**Our ref:** NO/2023/115507/01-L01  
**Your ref:** 3/2023/0632  
**Date:** 25 August 2023

**PROPOSED EARTH BANKED SLURRY LAGOON 50M X 50M.  
LAND OFF PRESTON ROAD, LONGRIDGE, PR3 3BL**

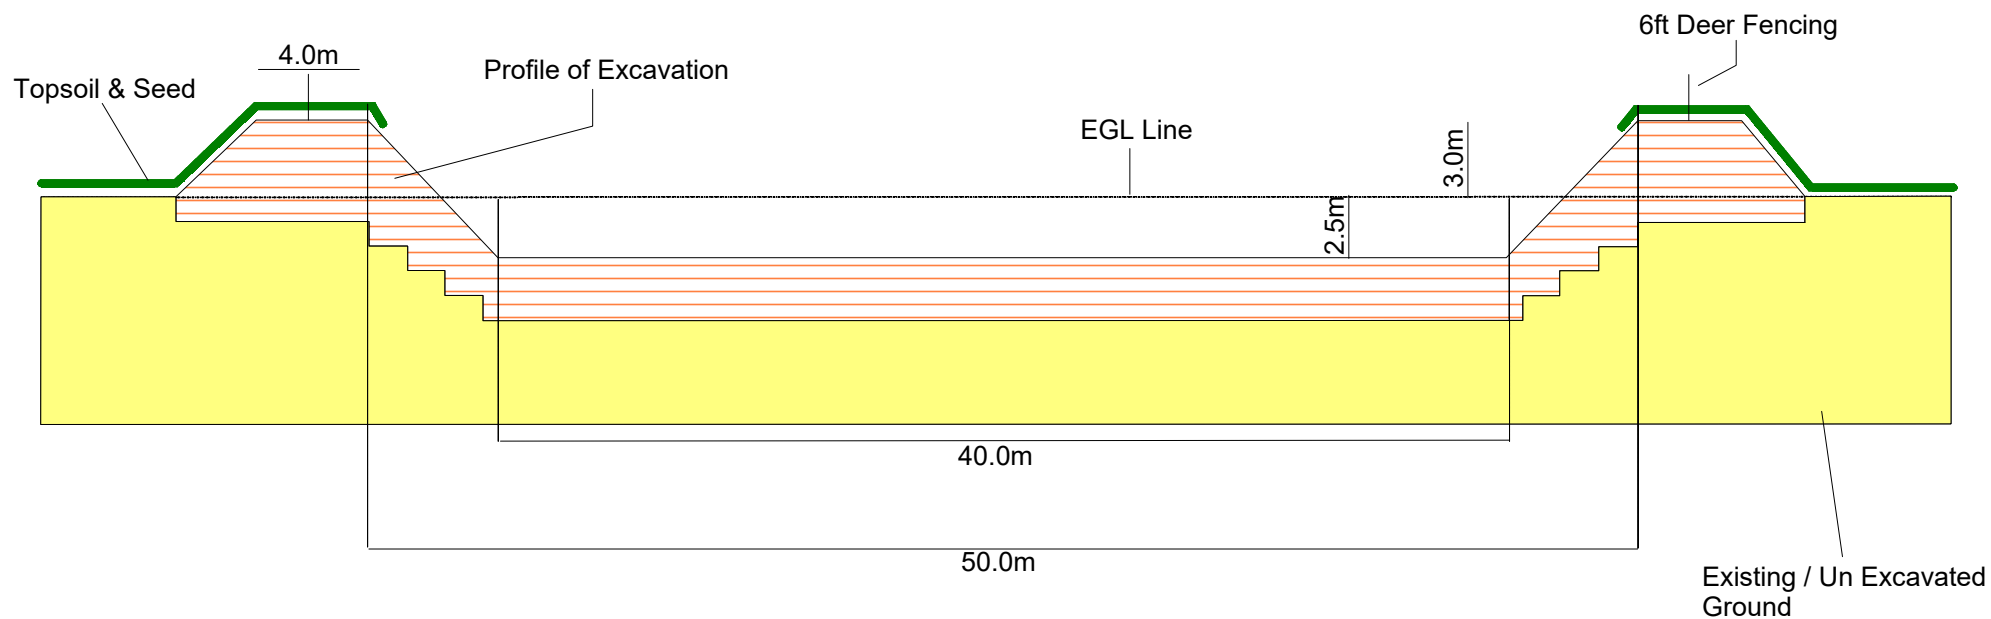
**Condition** Prior to the commencement of development, full details of any mitigation measures necessary to make the location of the lagoon suitable for the storage of slurry based on existing ground conditions shall be submitted to, and approved in writing by, the local planning authority. The scheme shall be implemented as approved.

As the proposal is for an earth-banked slurry lagoon, it will require an impermeable clay base to a minimum depth of one metre. To ensure compliance with SSAFO, the applicant will need to provide us with details of percolation tests to demonstrate that the ground conditions at the base of the lagoon are appropriate. Where permeability tests show that the soil or underlying ground is not suitable, it will be necessary to use a synthetic material or import impermeable soils to act as a liner for the lagoon. The earth banked walls will also need sampling as sufficient clay soils (not less than 20% and no more than 30% clay content) are required to make the banks stable. The lagoon should be sited sufficiently far away from any watercourses and land drains.
